This is to certify that 574 ASSOCIATES DBA: OTTO'S Located At 574 CONGRESS ST

Job ID: 2012-07-4527-ALTCOMM

has permission to Install partions/fire doors/2nd fl exit enclosure
provided that the person or persons, firm or corporation accepting this permit shall comply with all of the provisions of the Statues of Maine and of the Ordinances of the City of Portland regulating the construction, maintenance and use of the buildings and structures, and of the application on file in the department.

Drawing Name: FIRE RATED STAIR / CORRIDOR ENCLOSURE

**2 PROPOSED PLAN**  
SCALE: 1/4" = 1'-0"

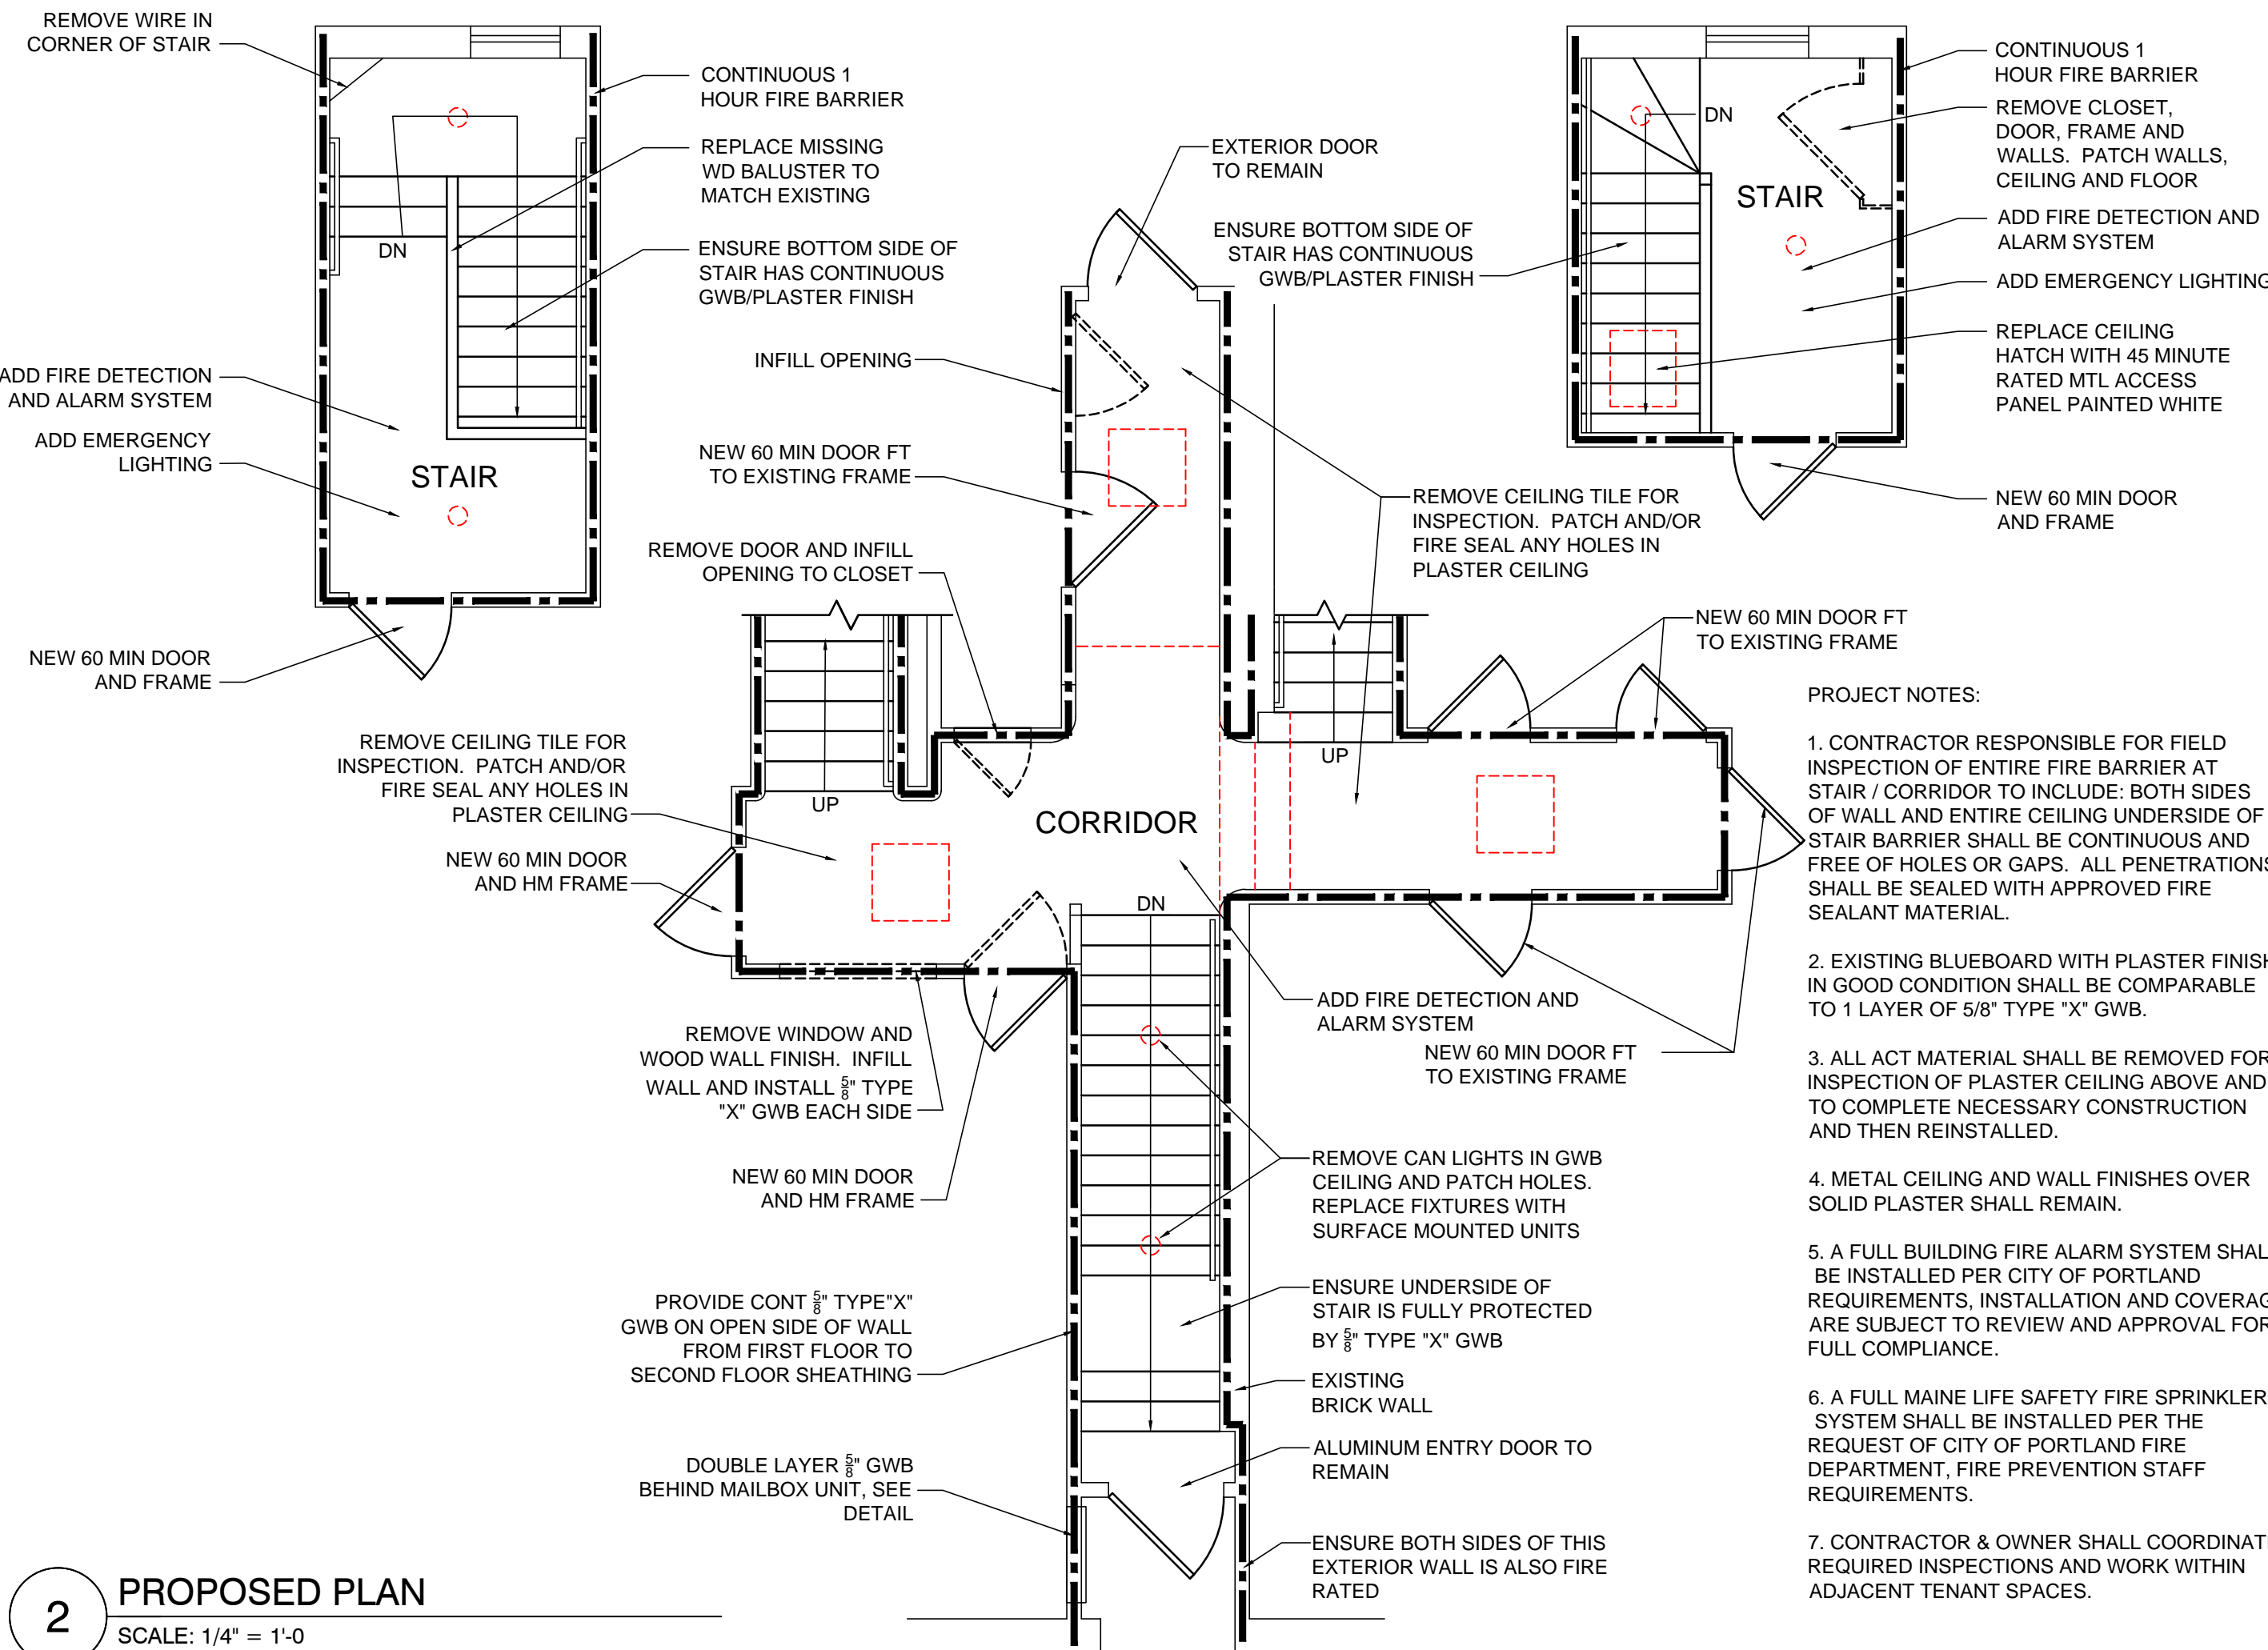
The plans still say "fit to existing frames" for the fire doors. They need to be rated frames and where they're replacing unrated frames it may be less expensive to go with standard size fire doors and save over custom size doors.

Same comment; the door assemblies must be 60-minutes per 101:8.3.4.2 and that includes rating the frames and a commercial self-closing device.

1. Are you treating the stairs and corridors as the exit enclosure? I would think this would be the case as this is the only egress. If so, the walls are considered fire barriers per Sec. 707, and therefore the opening protection (fire doors) are required to be 60 minute per Table 715.4.

Attached is the final plan with new and existing frames noted as discussed with the owner and Capt Pirone this afternoon. It is our understanding a building permit can be ready sometime Monday.

Keeping the existing heavy solid wood frames was the original plan. Changing them will require tearing off all the original wood moldings and most likely disturbing the solid plaster. If this is the direction the city requires I will make that change too.
